INTAKE COMMENTS CST		Reviewer	Norine.Allerdice@mercerisland.gov				
		Email	Norine.Allerdice@mercerisland.gov				
		Status	Accepted				
		Intake #	Submittal 3

DATE	4/8/2024	TIME		PERMIT #	2308-092	
Project Address	6202 SE 22ND ST, MERCER ISLAND					
Applicant	SHANE KATSOOLIS			Owner		
Scope of Work	ADDITION TO SFR

INTAKE COMMENTS Civil/Site/Utilities	Reviewer	Ruji Ding
	Email	Ruji.Ding@mercergov.org
	Status	Not Accepted – Resubmit Entire Submittal Package for Reviewer Approval
	Submittal	Third Intake Screening

EXISTING SITE COVERAGE PLAN

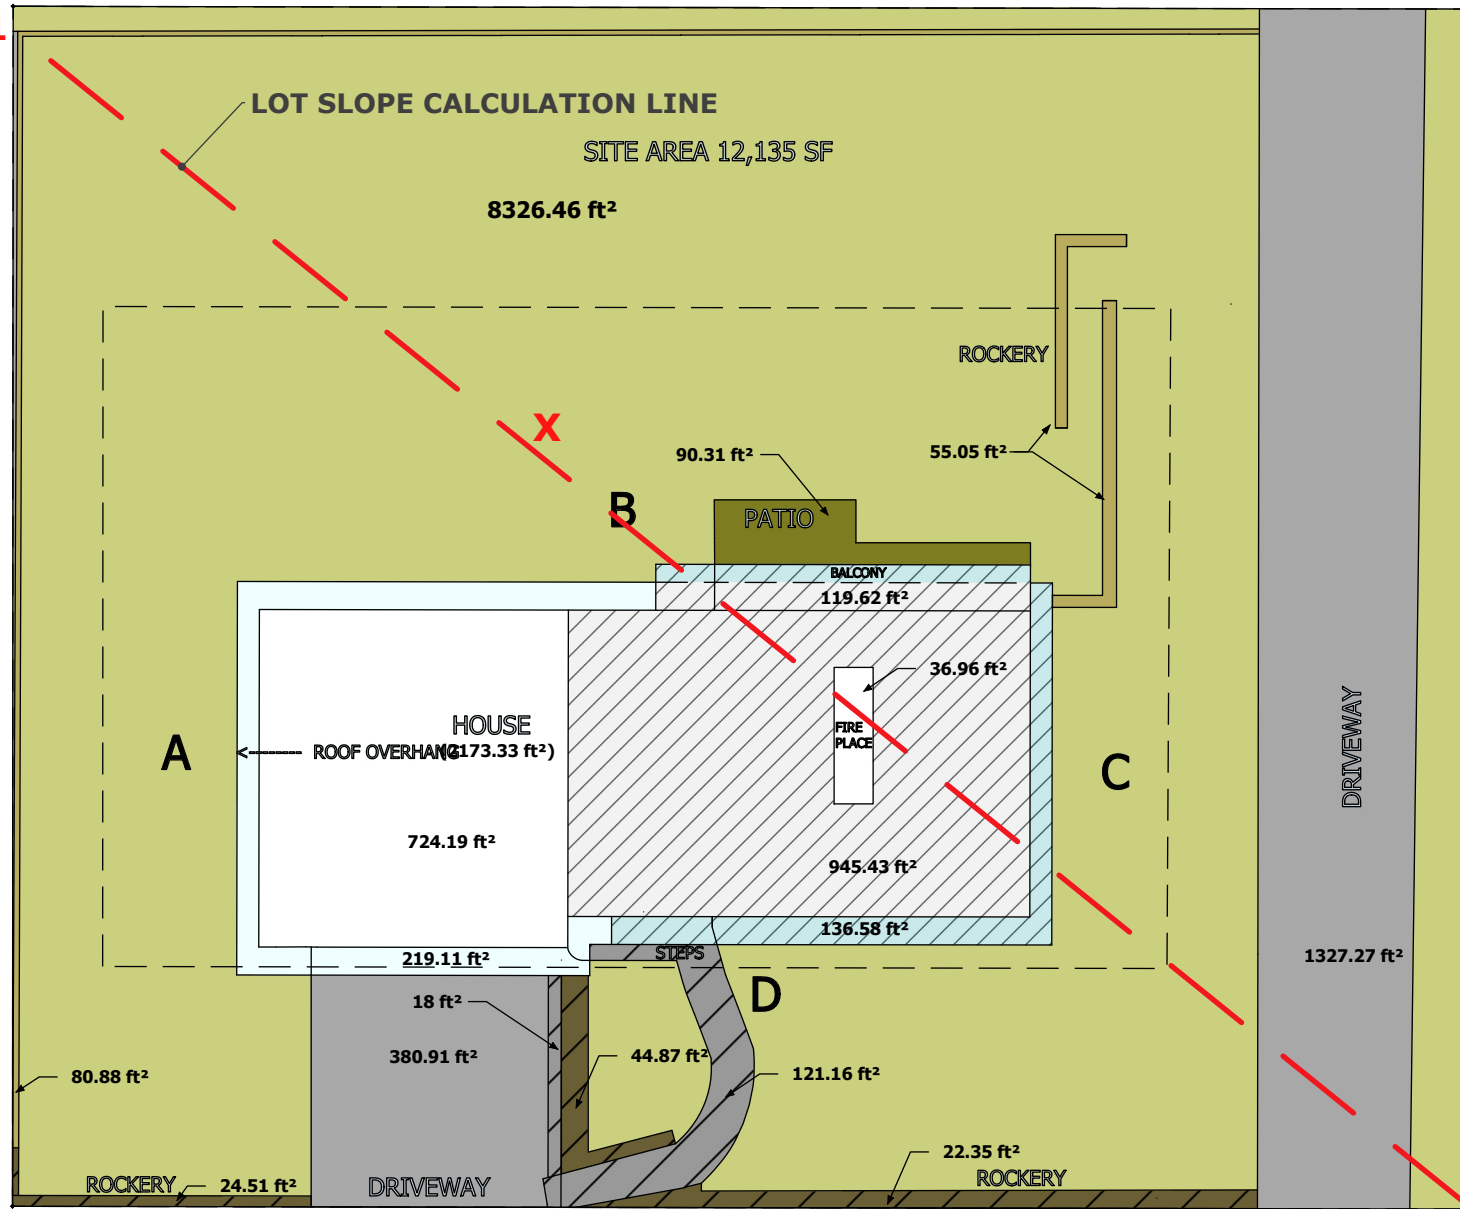
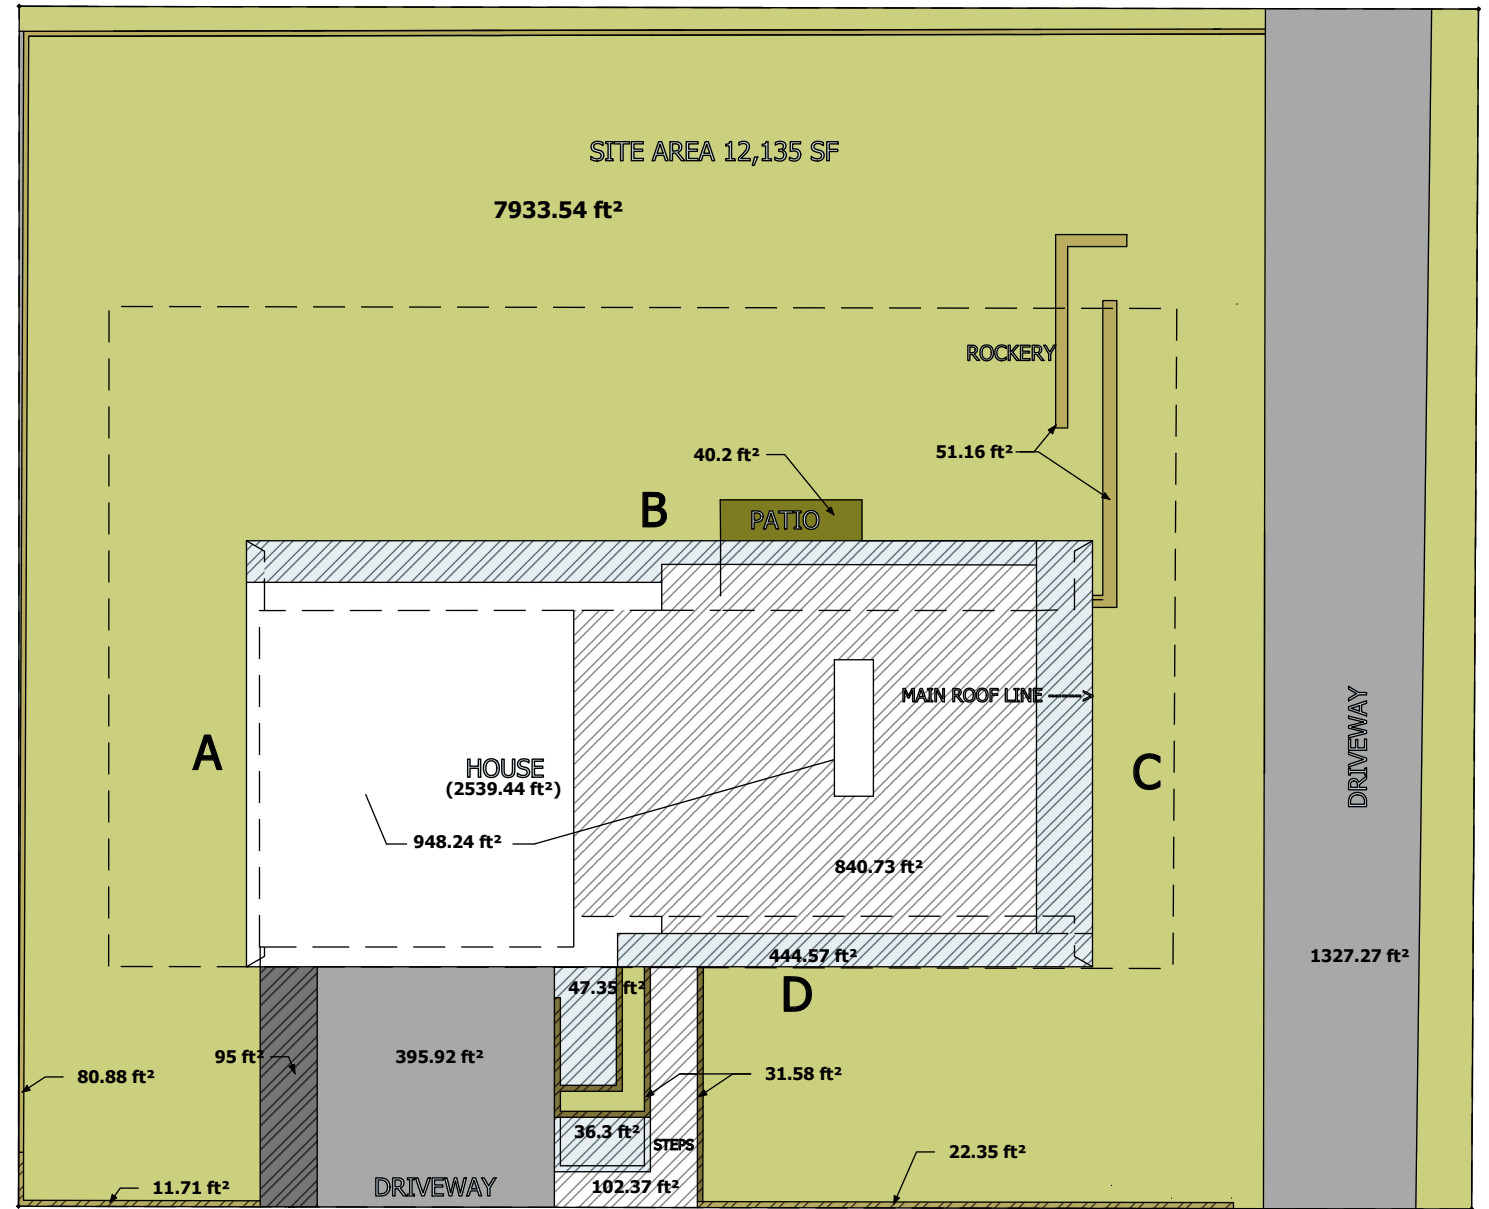
Project Area is <2000SF. Adjustments have been made to reduced areas to come in at a Net Project Change of <500SF. See sheet A-24 SITE AREA CALCULATIONS Graphic Plans and Stormwater Calculations

ELEVATION DEMO AREA

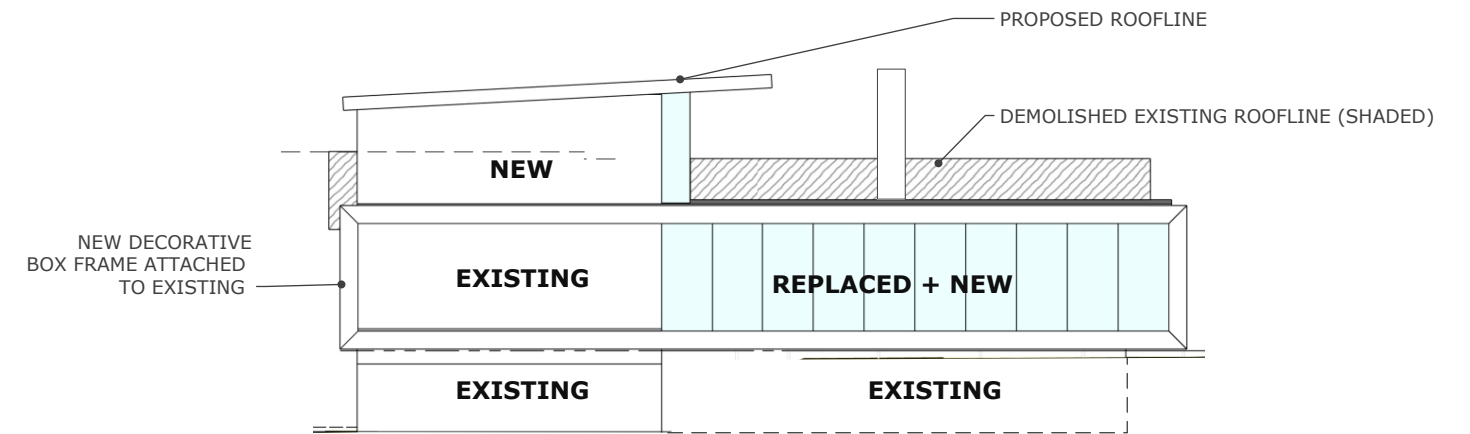
(3) Sheet A-25 does not provide the level of details of the removal of the eastern part of the house. Please provide construction sections (North-south, and east and west), similar as the section shown on A-18 to determine if the project will trig a full drainage review, and the removal of the eastern part of the house will be considered as new plus replaced hard surface.
--

Sheet A-17 addresses the demolished area with a shaded area. The existing ADU, stair and garage as well as the bedrooms and bathrooms remain intact. A-25 also shows this in a shaded area where only the roof is removed over the bedroom area. A24 Shows the Replaced and New hatched separately and the total is combined in the Stormwater Calculations table on the same sheet.
